**Dogger Bank South Offshore Wind Farms Project**

**PINS Reference: EN010125**

**Response to Rule 17 letter 24 October 2024**

Figure: 16-2 Drawing No: PC2340-RHD-OF-ZZ-DR-Z-0591

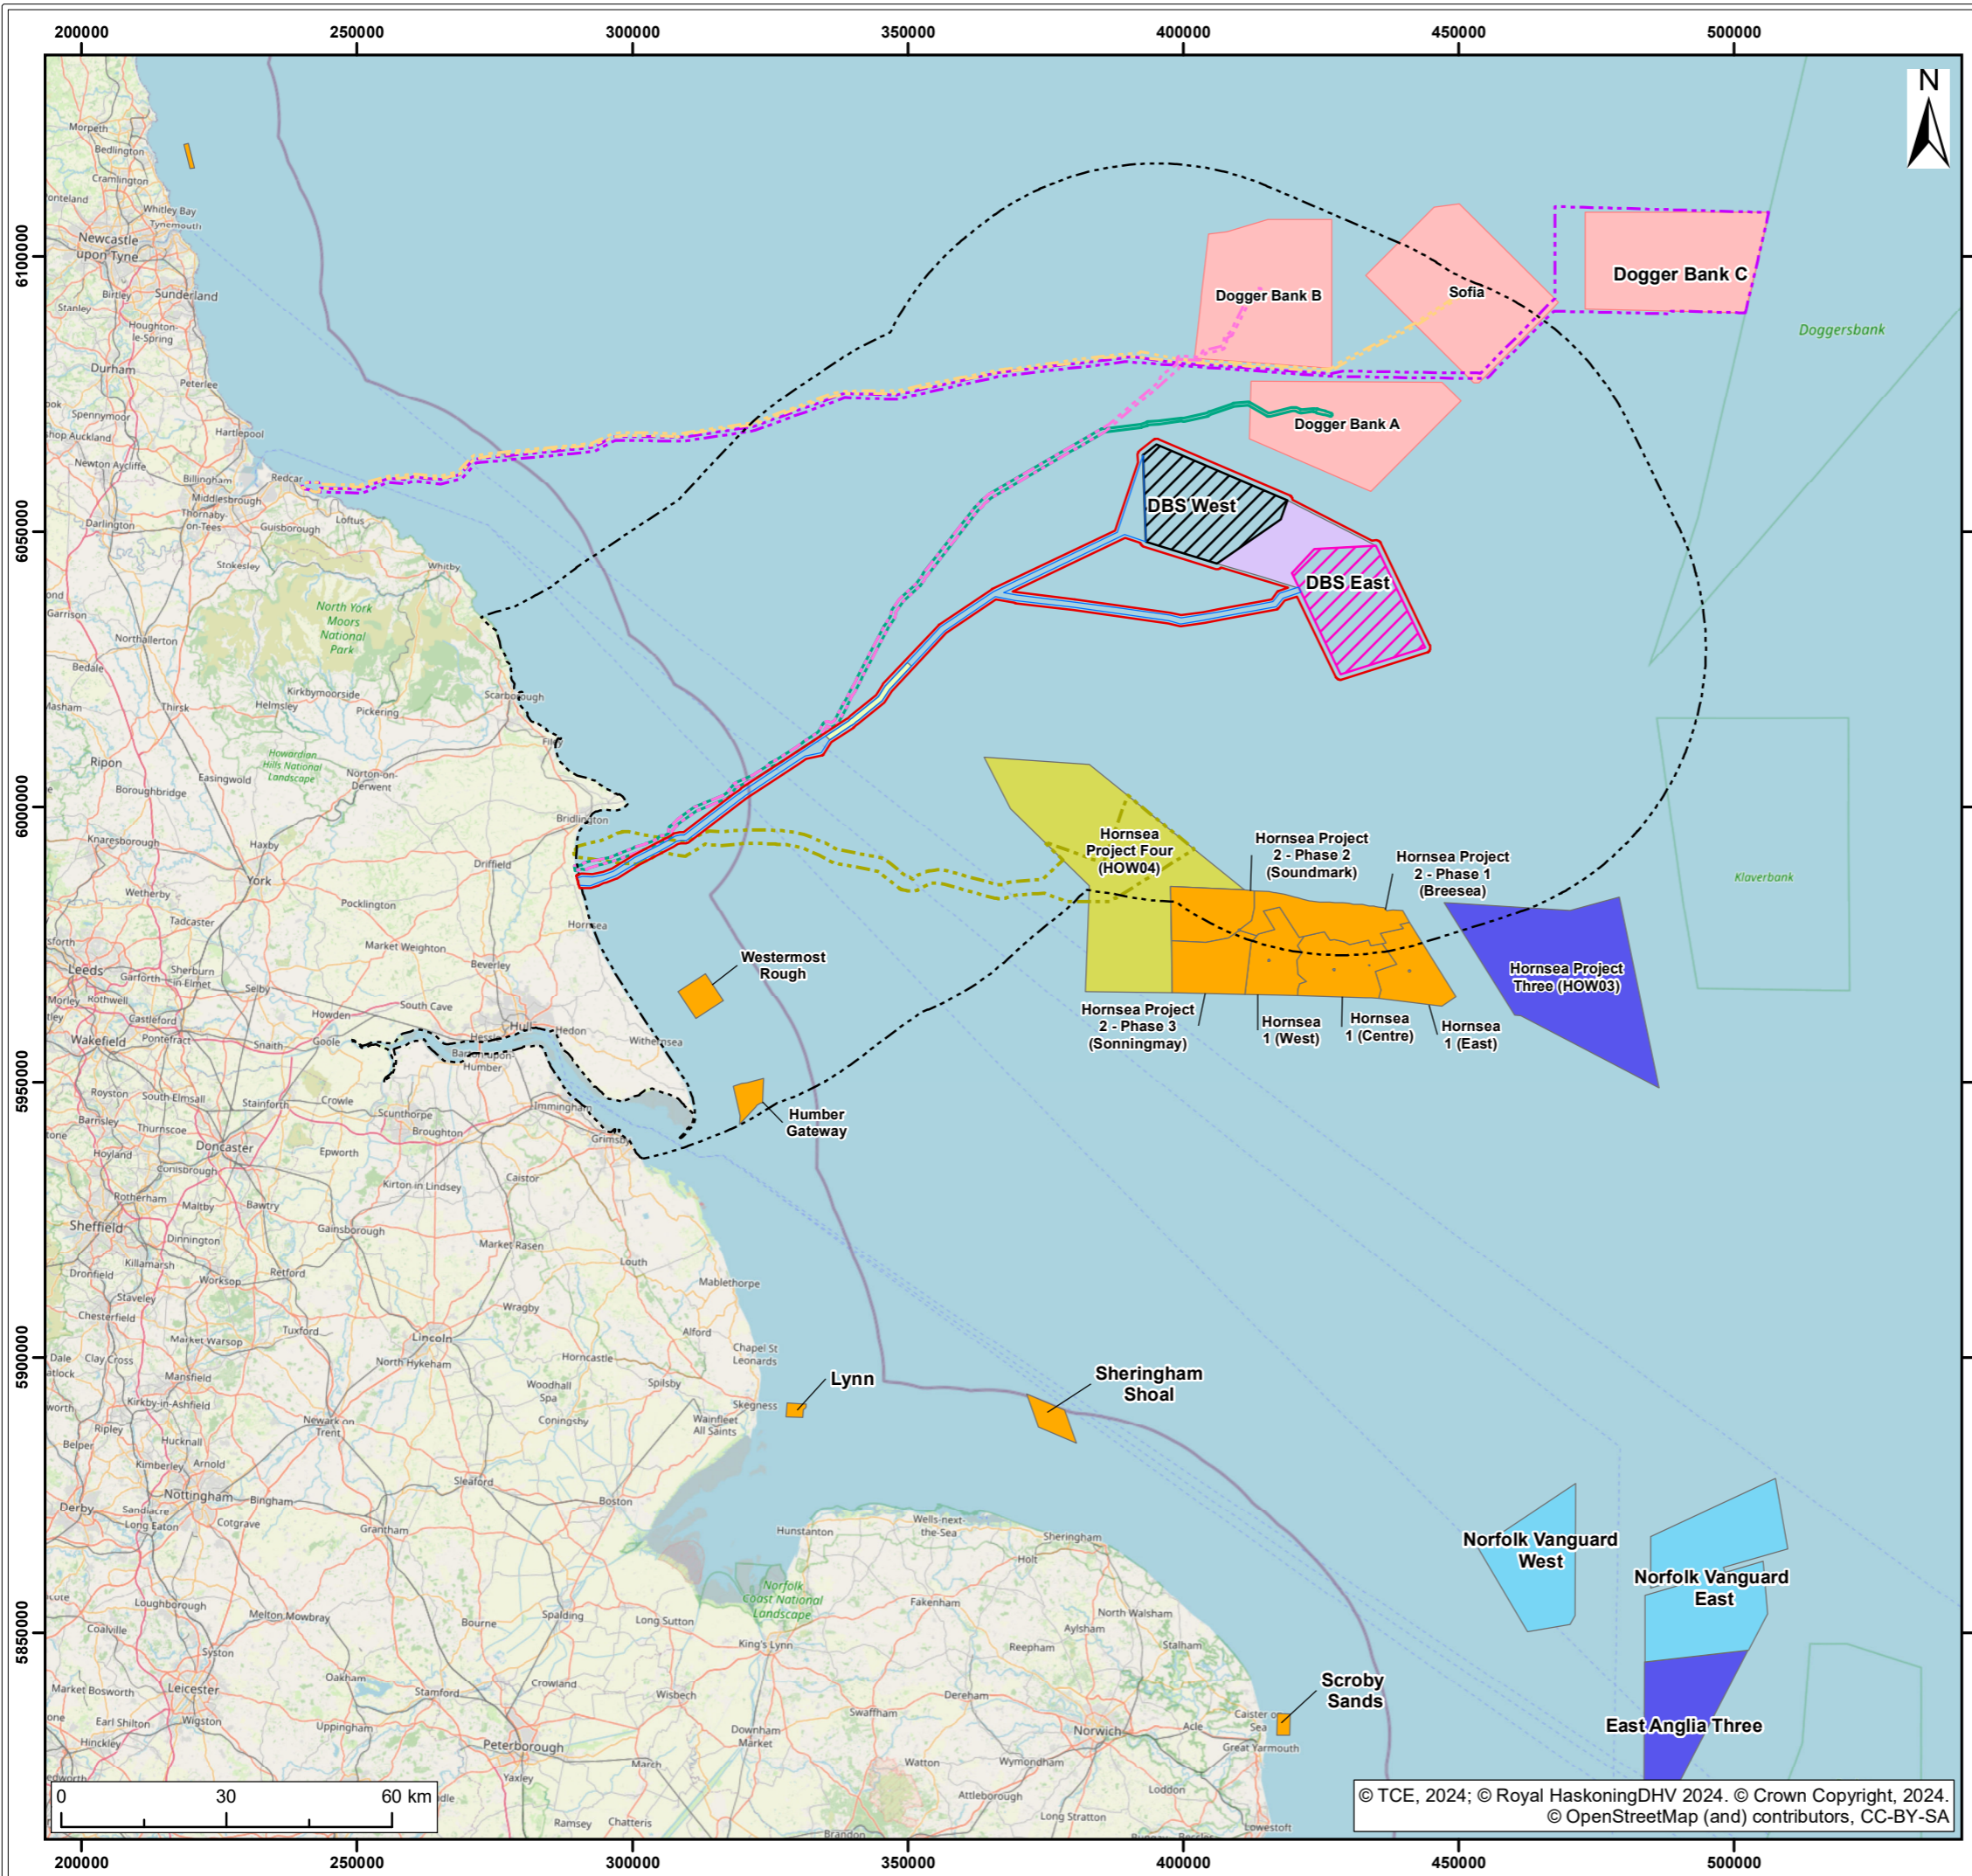
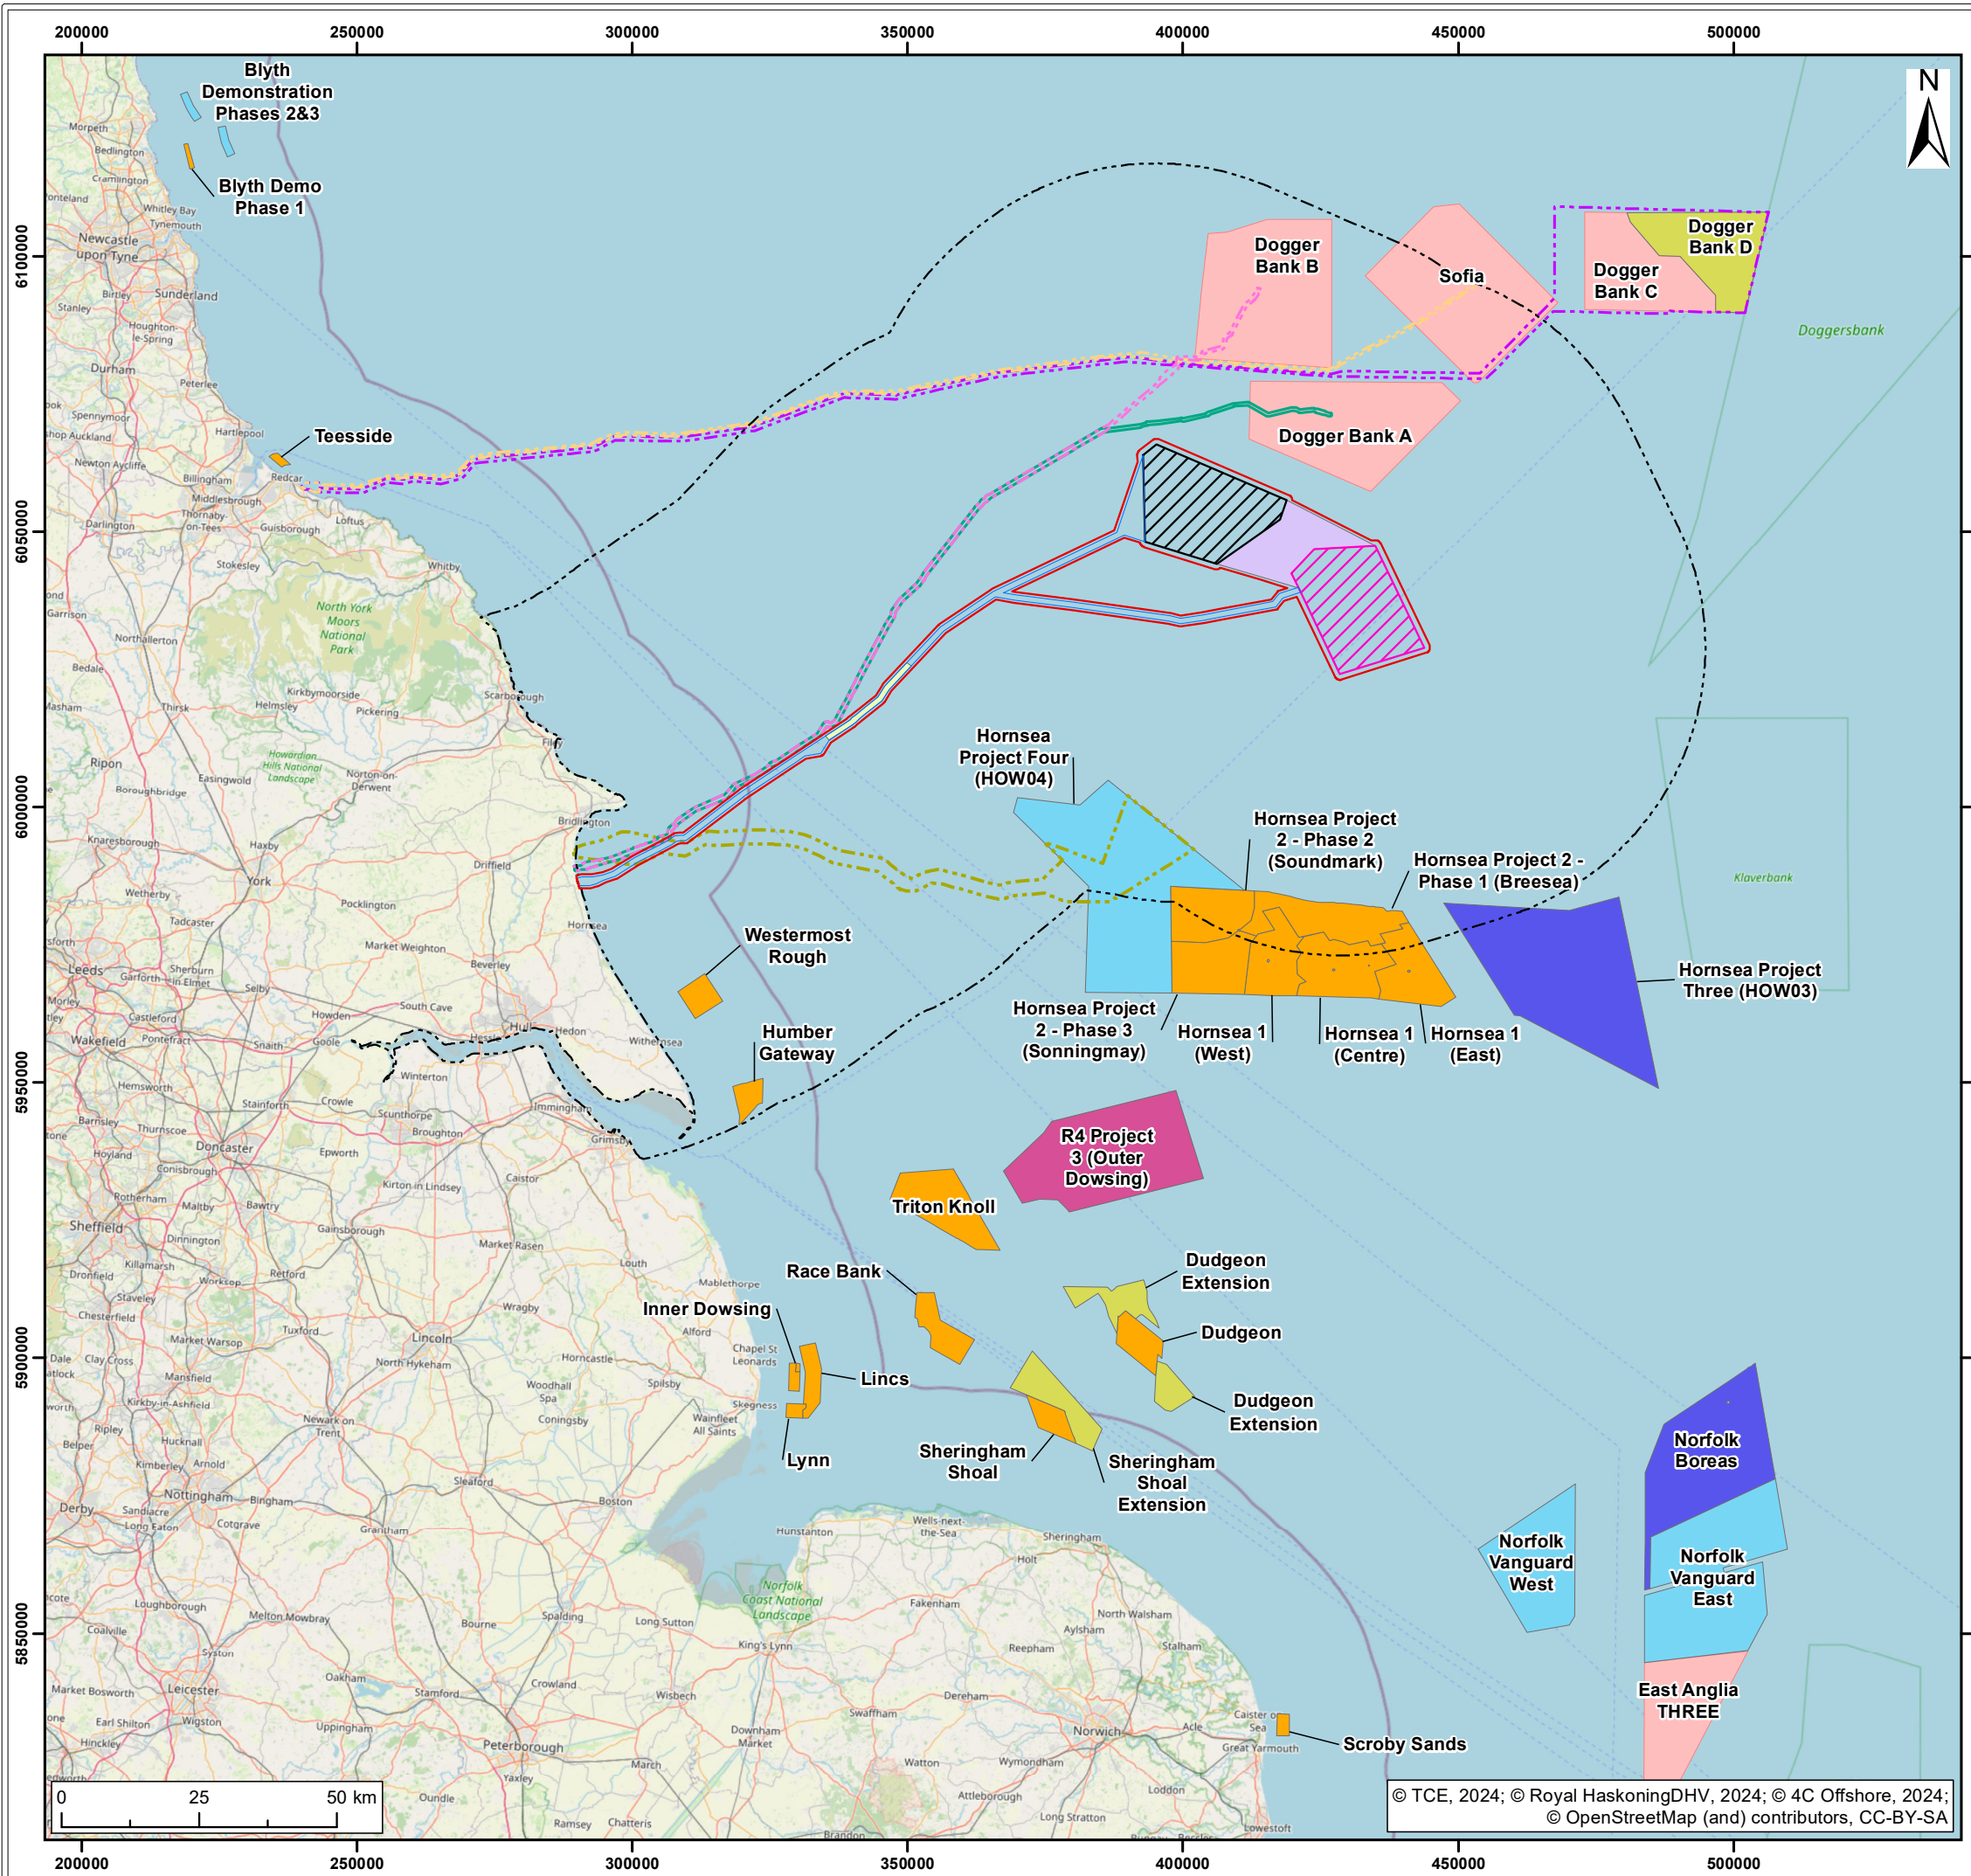
<p><b>Chapter 16 Infrastructure and Other Users</b> [APP-130, paragraph 37] states that the only offshore wind farm in planning is ‘Dogger Bank D’, however this is not shown on Figure 16-2 of [APP131]. Furthermore, Figure 16-</p>	<p>The Dogger Bank D Scoping Report was submitted on 21 April 2024, after the drawing was prepared for DCO Submission. Hornsea Project Four was consented at the time of submission as noted in the text for Chapter 16. The colour coding on the Figure 16-2 showing Hornsea 4 as “In Planning” was incorrect.</p>	<p>Submission in response to the Rule 17 letter 04 November 2024</p>

Query	Response	Date to be provided
<p>2 of [APP-131] shows ‘Hornsea Project Four’ as “in planning” which would appear to be incorrect as it is consented. Please review these documents and update and amend as necessary.</p>	<p>The document <b>Figure 16-2</b> [APP-131] has been revised to reflect the above.</p>	
<p>Onshore Historic Environment</p>		
<p>Update <b>Chapter 22 Onshore Archaeology and Cultural Heritage</b> [APP-172] to provide an assessment of lighting effects on heritage assets and their settings as a result of the Proposed Development during construction and operation.</p>	<p>The requested assessment is being progressed and will be provided on 22 November 2024.</p>	<p>22 November 2024 (previous Draft Deadline 2)</p>
<p>Update <b>Chapter 22 Onshore Archaeology and Cultural Heritage</b> [APP-172] to provide an assessment of the effects on heritage assets on an individual asset basis, rather than as grouped assets.</p>	<p>The requested assessment is being progressed and will be provided on 22 November 2024.</p>	<p>22 November 2024 (previous Draft Deadline 2)</p>
